Application number: 2026/91629	
What is the application for?:	Demolition of existing garage and erection of two storey side extension and sing
Address of the site or building:	37, Wyvern Avenue, Marsh, Huddersfield, HD3 4BH
Postcode:	HD3 4BH

913 - 003 - REV C

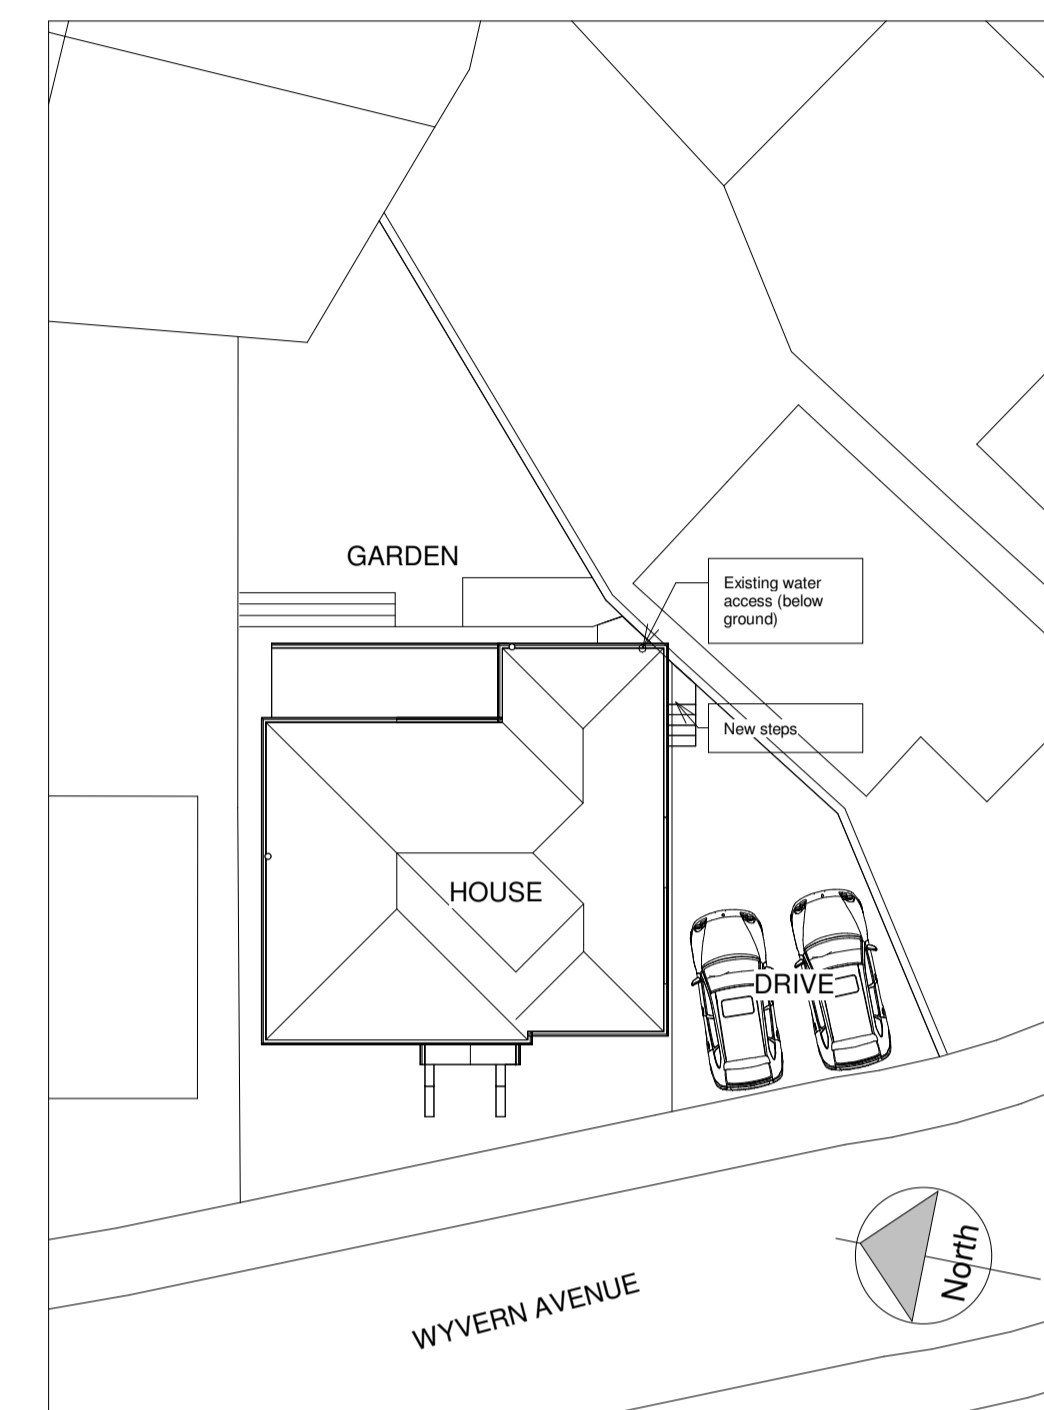
Type of comment: A general comment	
Do you wish your comments to be published on the website anonymously?	Yes
I have had to report the overgrown vegetation on this land for the last 10 years where the land owners then park on the pavement forcing pedestriians into the road on the corner. If there is a driveway on the corner now it will block the visibility for drivers and cause safety issues when using the driveway.
